STATE OF WASHINGTON  
DEPARTMENT OF ECOLOGY

October 11, 2011

Re: SP-11-00008

Thank you for the opportunity to comment on the short subdivision of approx 29.53 acres into 2 lots, proposed by Sharon M. Simmons. We have reviewed the application and have the following comments.

SIMMONS SHORT PLAT
 NW 1/4 SECTION 15 TWP. 17 NORTH, R. 19 EAST, W.M.
 KITTITAS COUNTY, WASHINGTON

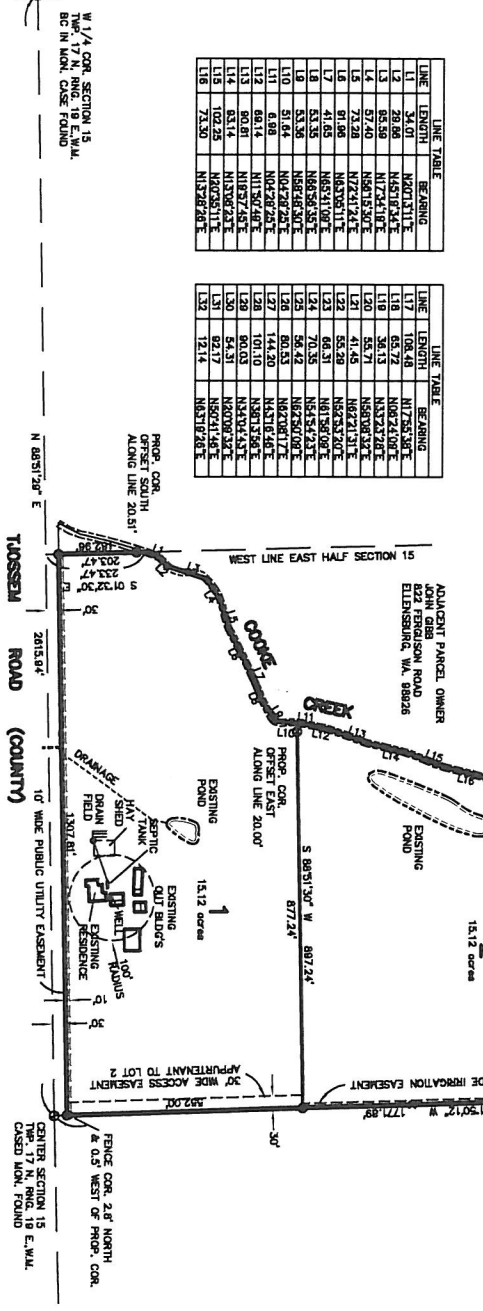
The National Wetland Inventory Map identifies the pond on proposed lot 2 as an excavated pond, however, it may still be jurisdictional if the source of the water in the pond is the perennial waterway located to the west of and adjacent to the pond. This perennial waterway is part of a natural stream system that has been altered (straightened). Based on aerial photo review, the wetland area may extend beyond the boundaries of the open water pond area, especially to the north and south of the pond.

Any future development on site should be located outside of required wetland and stream buffers.
